Introduction

These comments relate to a full planning application for development of employment Class E(g) – ‘Commercial, Business and Service Uses that can be carried out in a residential area without detriment to its amenity’.

The northern part of the site is allocated in the Cherwell Local Plan (2015) as part of the Bicester 10 allocation and is intended to form the final phase of the Catalyst Bicester Business Park. There is an extant outline planning consent for the site, which was granted in 2017 reference 16/02586/OUT.

01 ENTRANCE CANOPY
018 front elevation

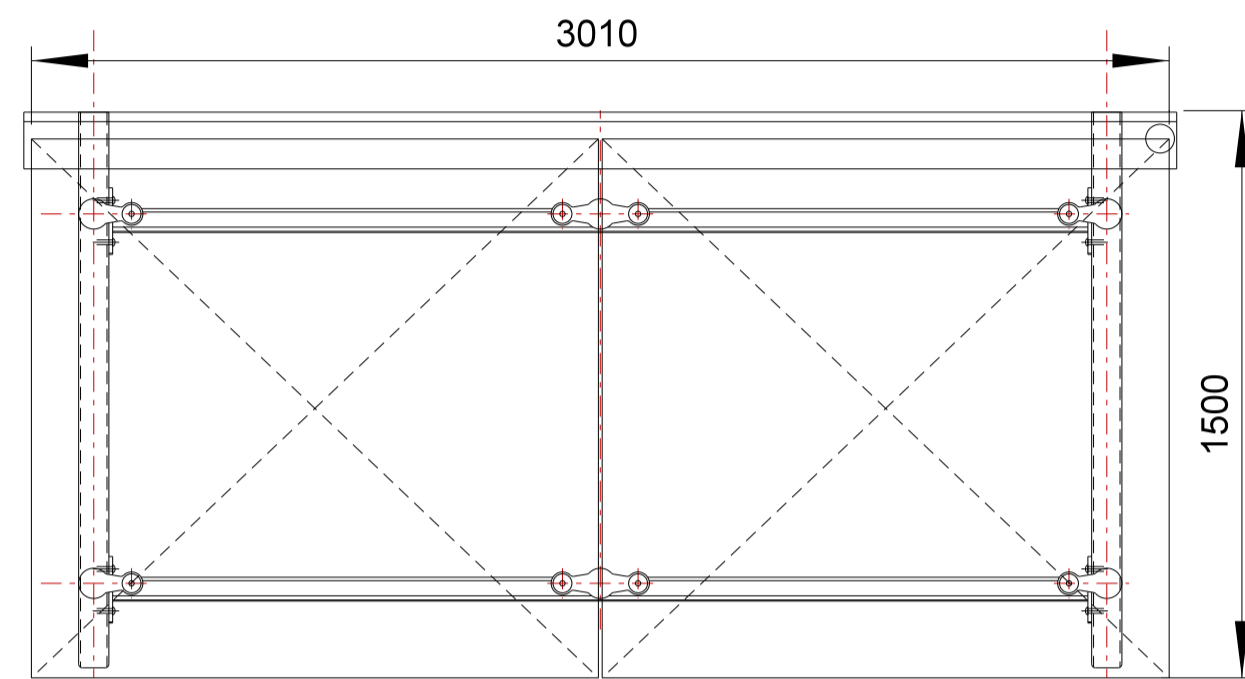
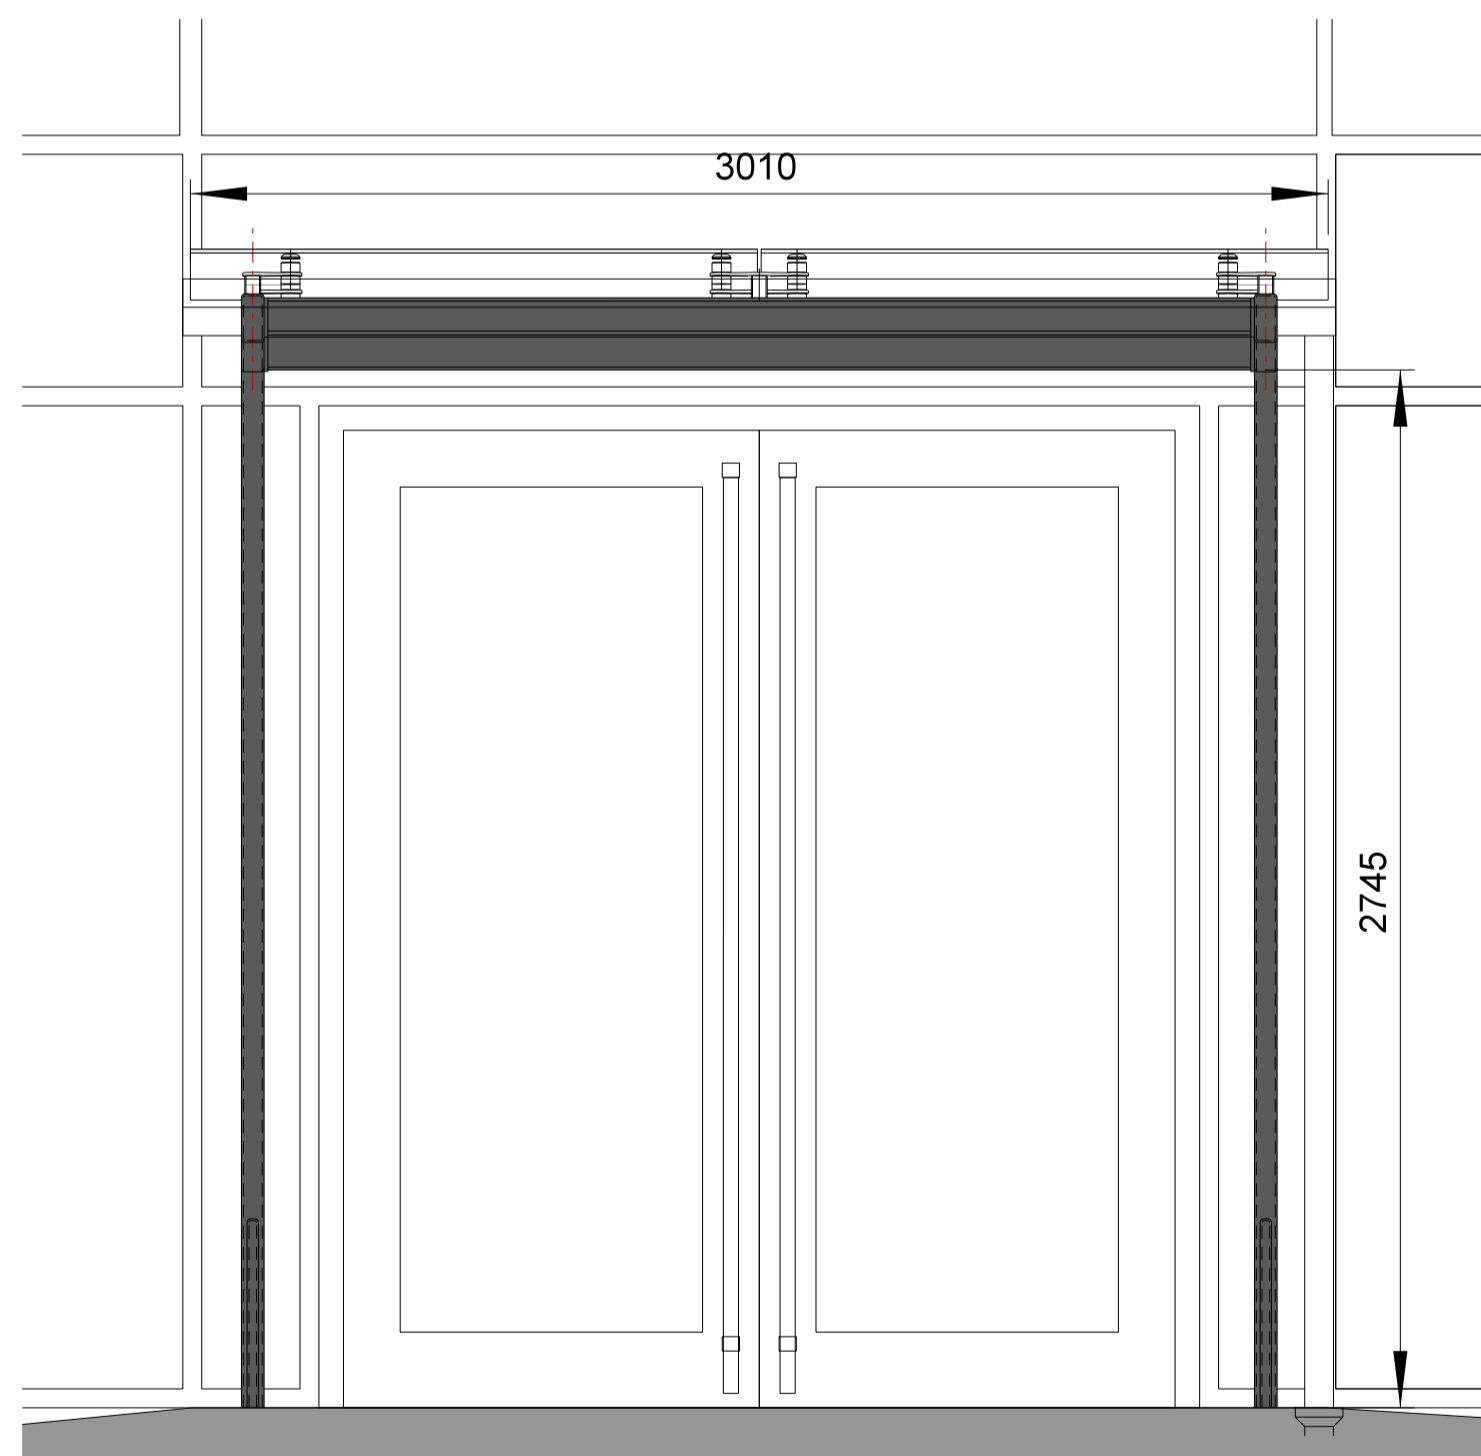
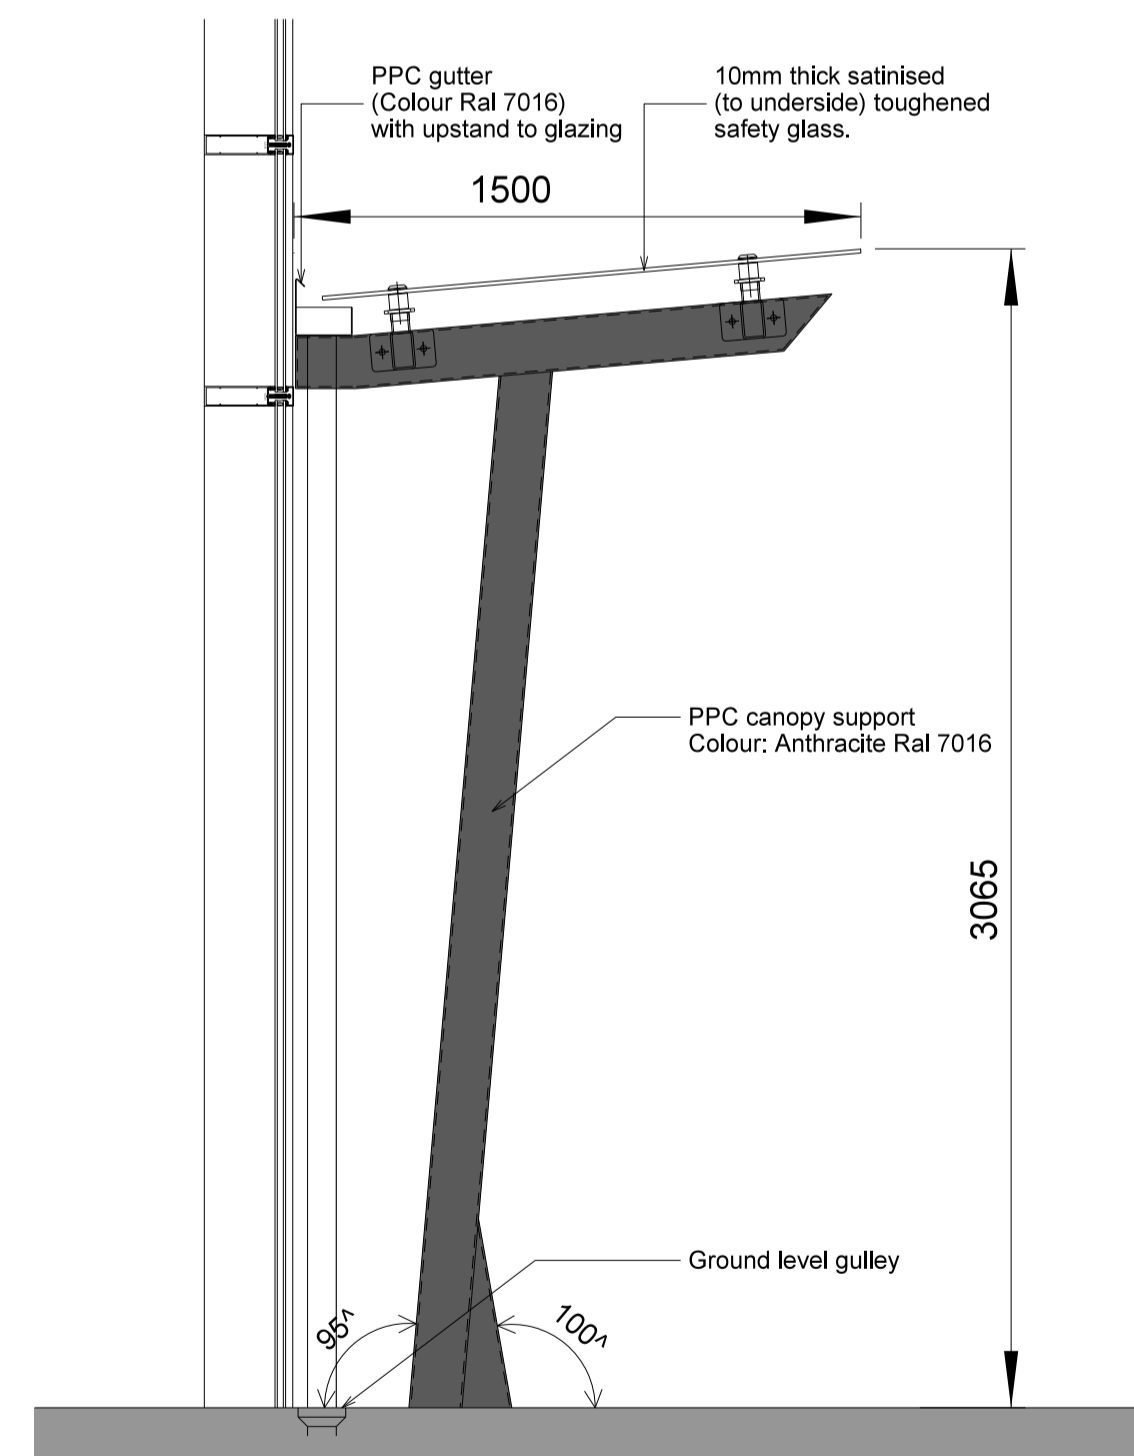
The proposed open cycle parking provision is not integrated into the design to provide an attractive, enclosed and secure facility. Paragraph H3 of the National Design Guide is clear that cycle storage must be conveniently positioned and sensitively integrated into public spaces, amenity space or buildings. To encourage cycling over car use, site user cycle parking should be provided at a visible location close to the main building entrances, within the built form or stand-alone secure stores

integrated into the public realm landscaping. The proposed Sheffield type stands and canopies are more suited to visitor/short stay cycle parking. Bin stores are also required to be well integrated into the design to minimize visual impact, unsightliness and clutter.
